Our ref: OUT22/3371

5 April 2022

**Subject: Broken Hill Battery Energy Storage System Modification 1 (SSD-11437498) -
Modification Report**

The proposed modification is to include the option of installing the Battery Energy Storage System (BESS) transmission line underground.

**FIGURE 4-2:**  
COMPARISON BETWEEN  
APPROVED PROJECT AND  
PROPOSED MODIFICATION

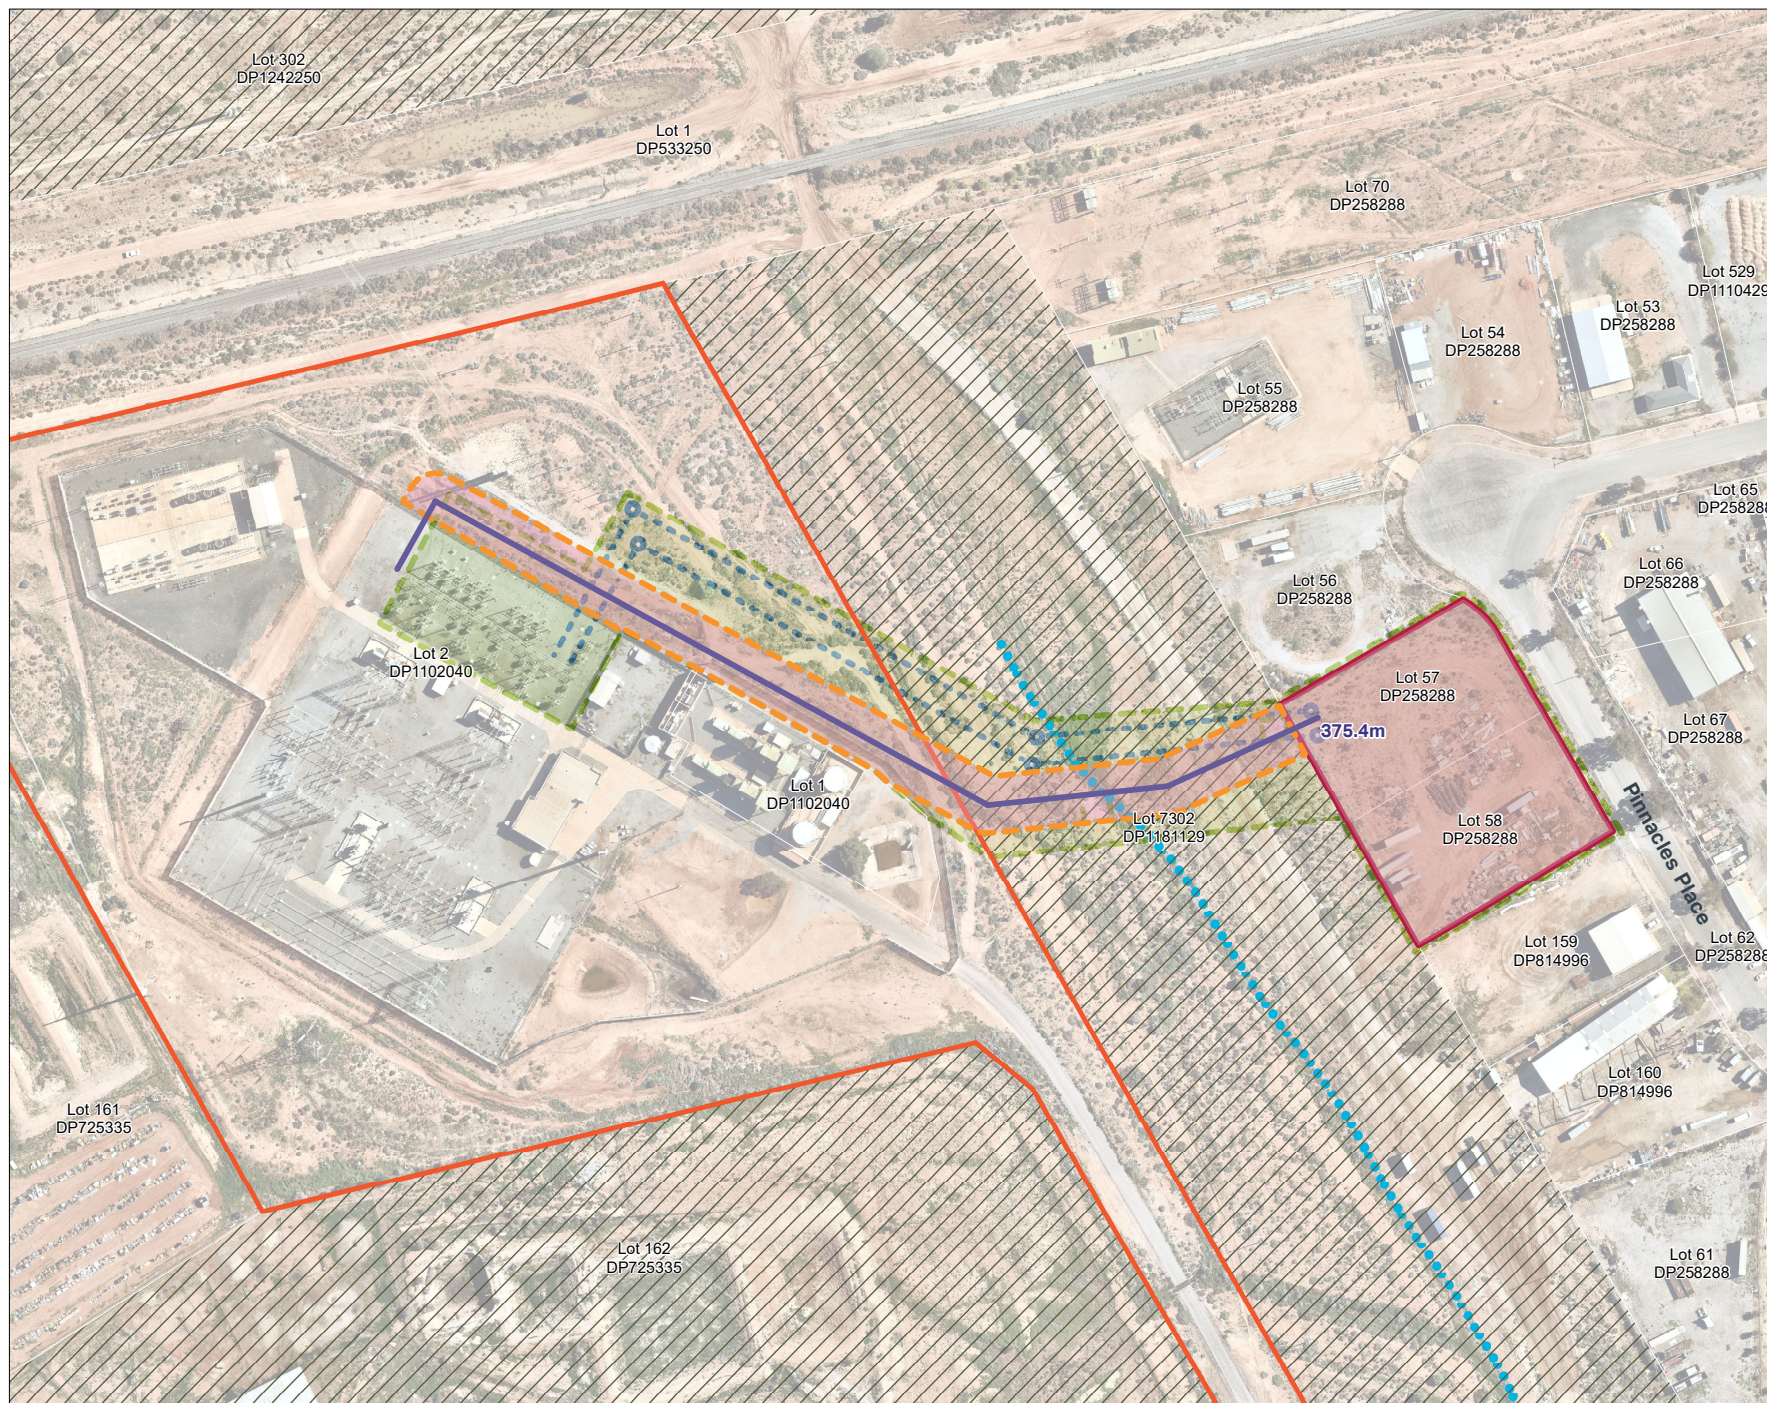
- Ensure appropriate trench depth combined with suitable stabilisation, rehabilitation and monitoring is implemented to minimise erosion of waterfront land and risk to transmission line infrastructure.
- Prepare a Soil and Water Management Plan to address stormwater management and sediment and erosion control. The plan is to address the requirements of the guideline *Managing Urban Stormwater: Soils and Construction* (Landcom 2004) and the *Guidelines for Laying Pipes and Cables in Watercourses on Waterfront Land* (NRAR 2018).

The proponent should ensure the transmission lines are installed at an adequate depth on waterfront land to prevent potential exposure during an erosion event. Appropriate stabilisation and rehabilitation techniques combined with monitoring will be necessary to minimise this risk and to prevent degradation of waterfront land.
